The Member-Secretary,
Chennai Metropolitan
Development Authority,
No.8, Gandhi-Irwin Road,
Chennai-600 008.

Letter No. A1/25587/2001

Sub: CMDA - Planning Permission - Construc-
tion of Residential/Commercial Building
at S.No.169 of Nandambakkam Village
Plot No.4 pt.of Sundar Nagar -

Basement
floor, GF and
First floor

SITE PLAN / GROUND FLOOR PLAN

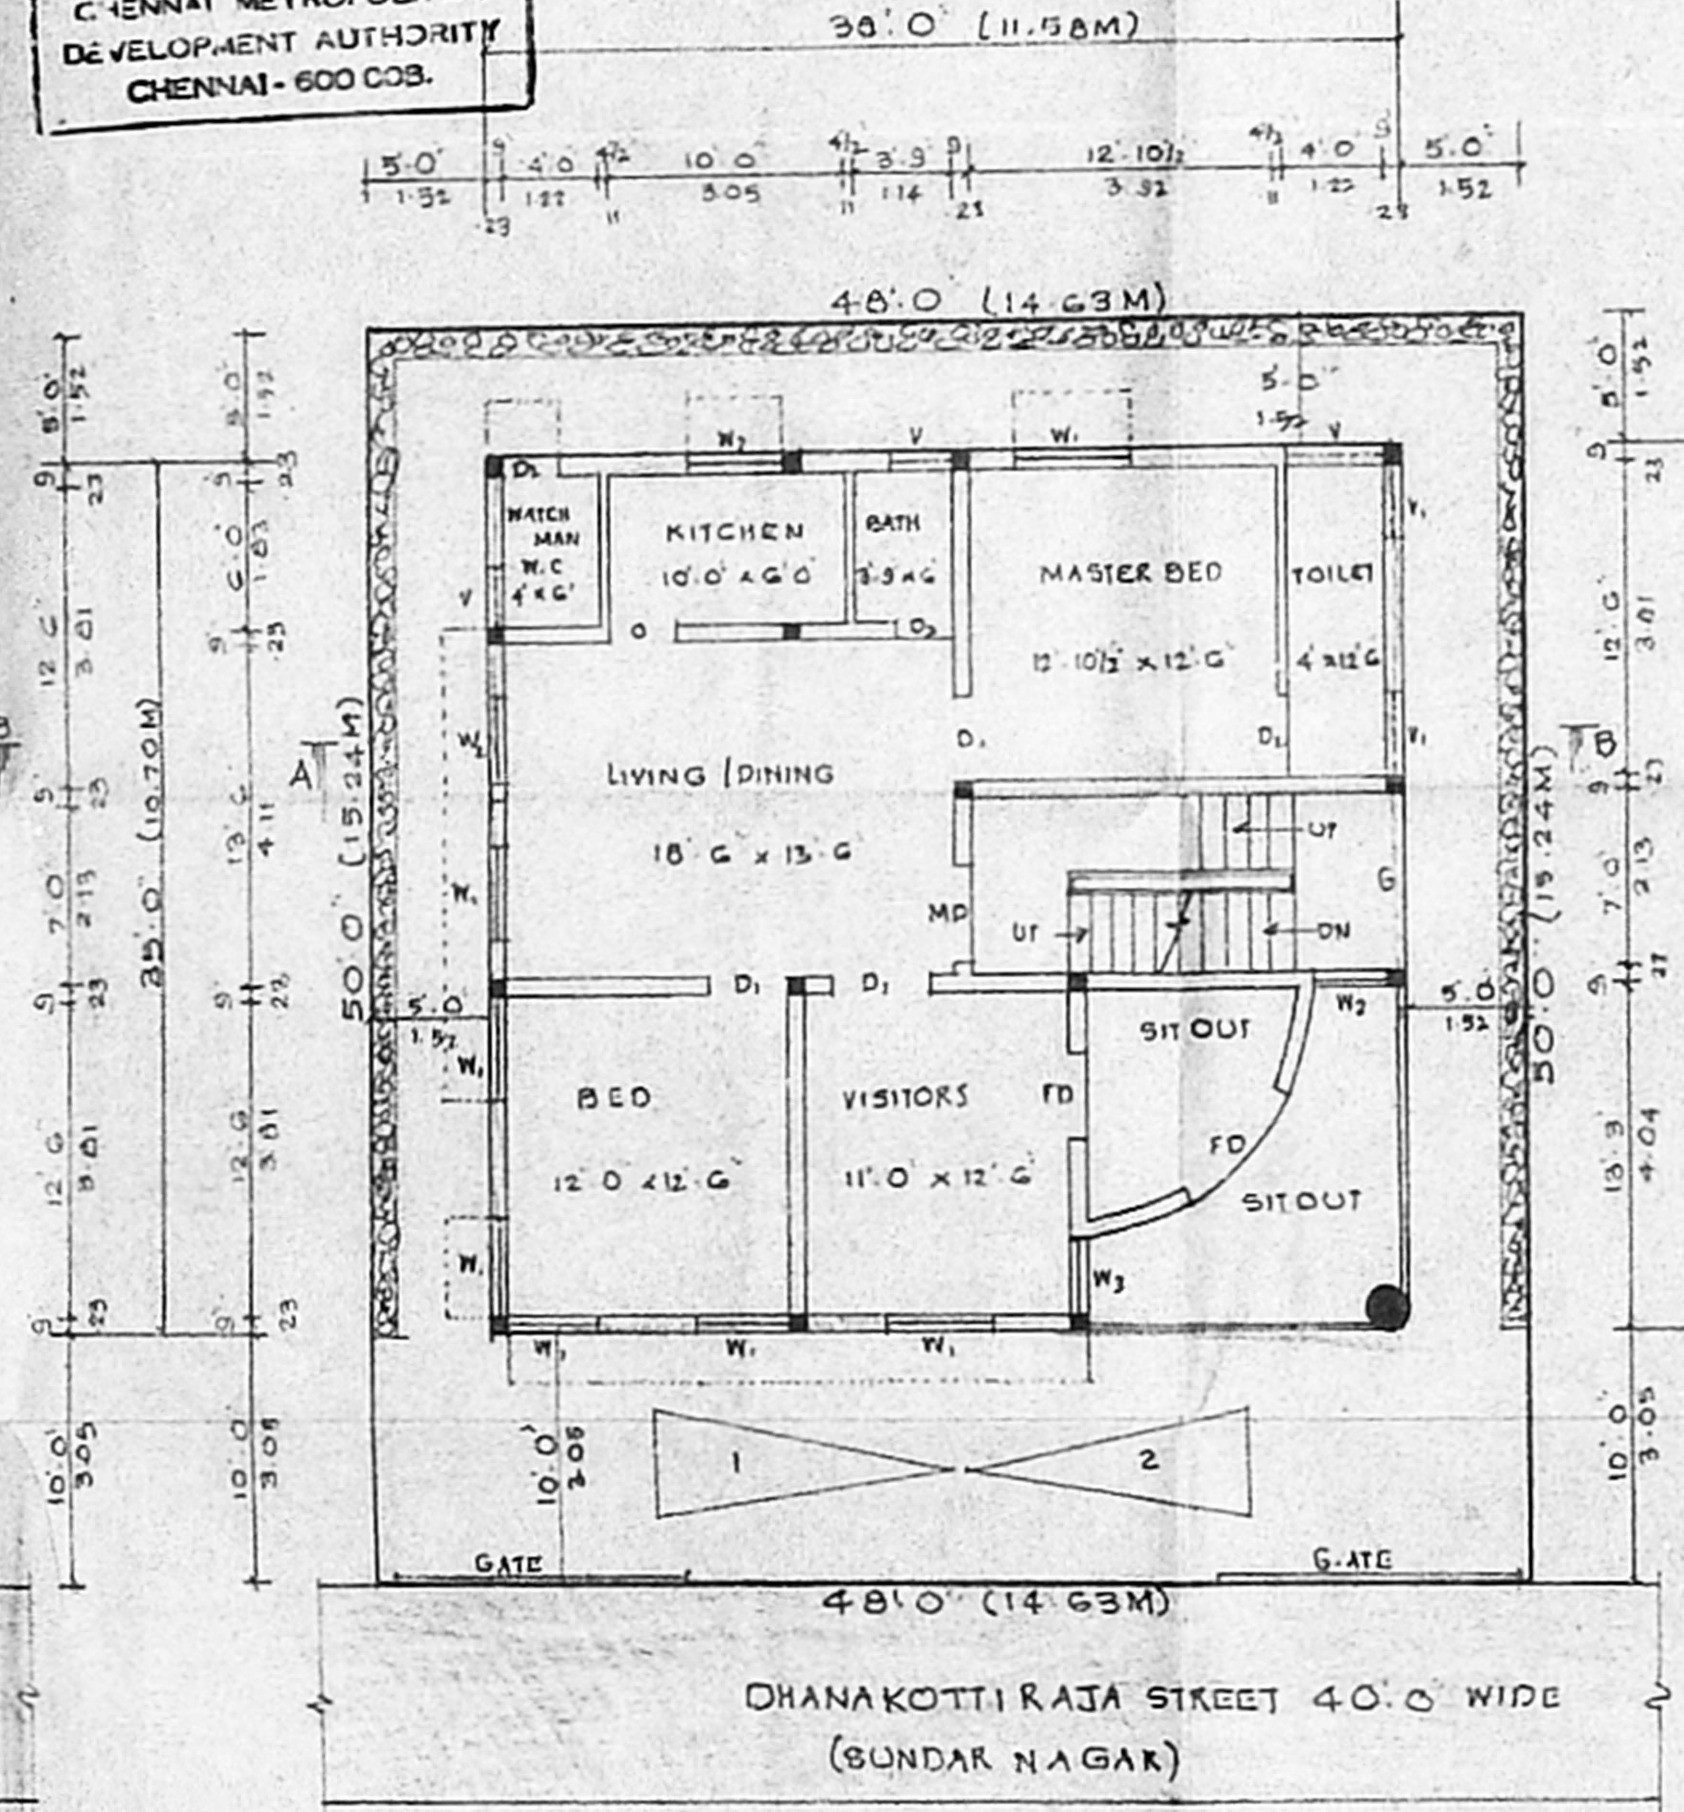
- a) Rain water conservation regulations stipulated by CMDA should be adhered to strictly.
- b) Subject to condition that applicant shall construct the front compound wall excluding the road widening land.
